Laurie Leader - Re: BP#2014-02489 565 Congress Street - Plan review comments

I am handling the plan review for 565 Congress Street and have the following questions:

Floor 1

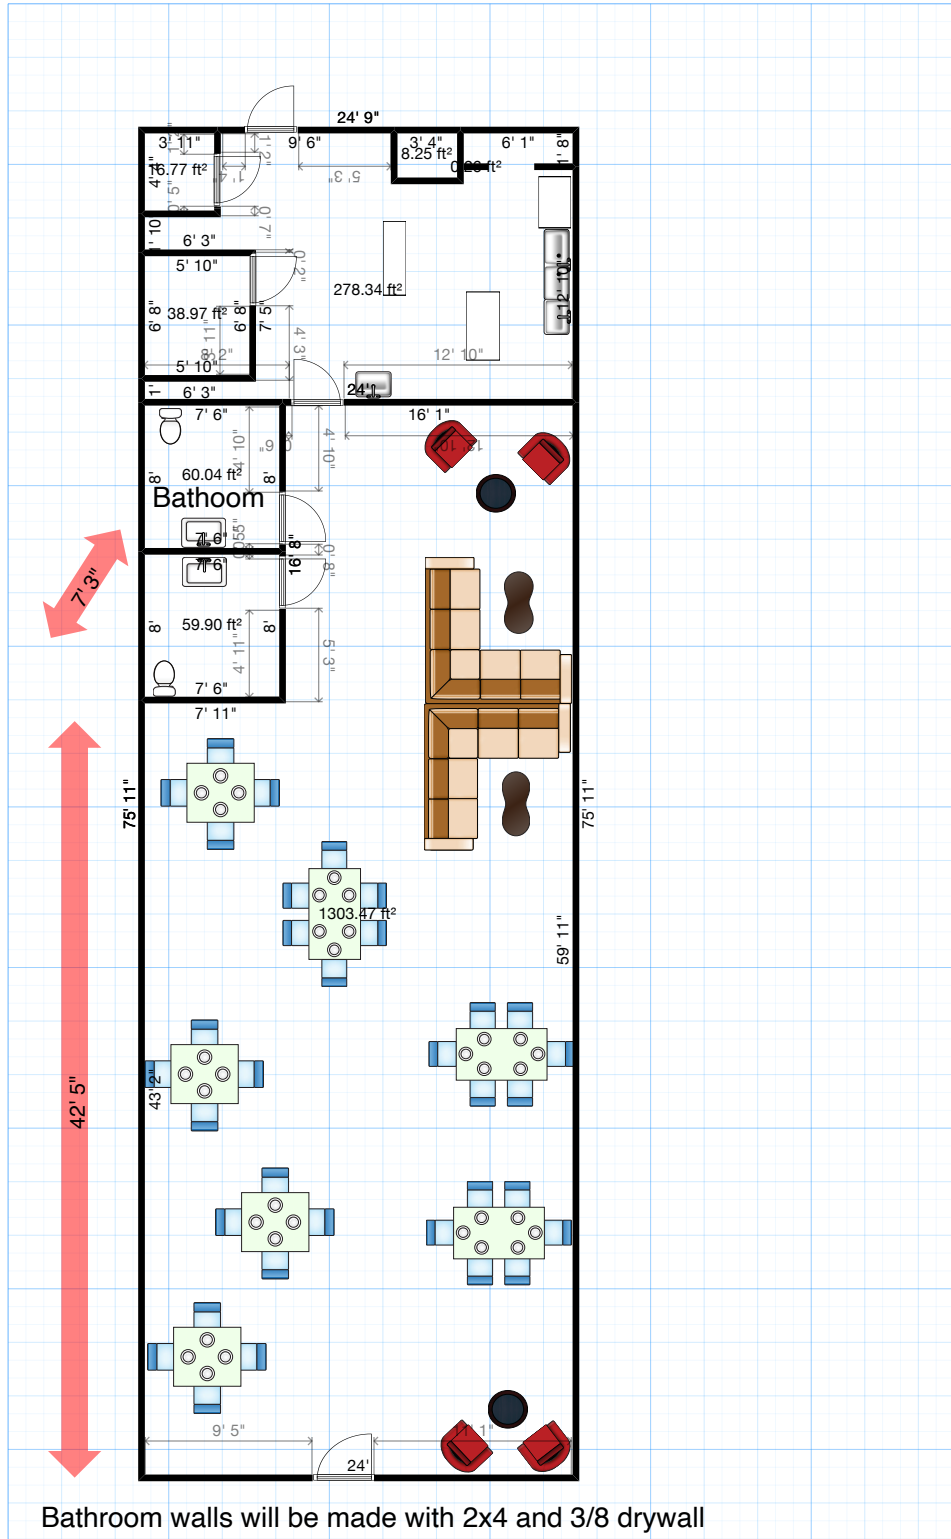
1. The scope of work shows this as an art studio previously. Was this, at a previous tenancy, ever a restaurant and is any portion of the kitchen existing?
2. Can you provide a better scope of work including clarifying the scope of work for the kitchen, labeling all kitchen equipment including prep area, dishwasher, floor drain, walk-in cooler, floor finishes in kitchen, etc. Is the walk-in cooler prefabricated or being built on-site?
3. Does this building have a basement area and if so, does the tenant have access to the basement.
4. Is the building sprinkled?

1. This was never used as a restaurant how ever the menu we are mostly cold items. Will be putting in all the proper sinks.
2. I can do that however there is no need for an walk in cooler.
3. Yes it does and, yes he does
4. Not to my knowledge, at lease not in my space
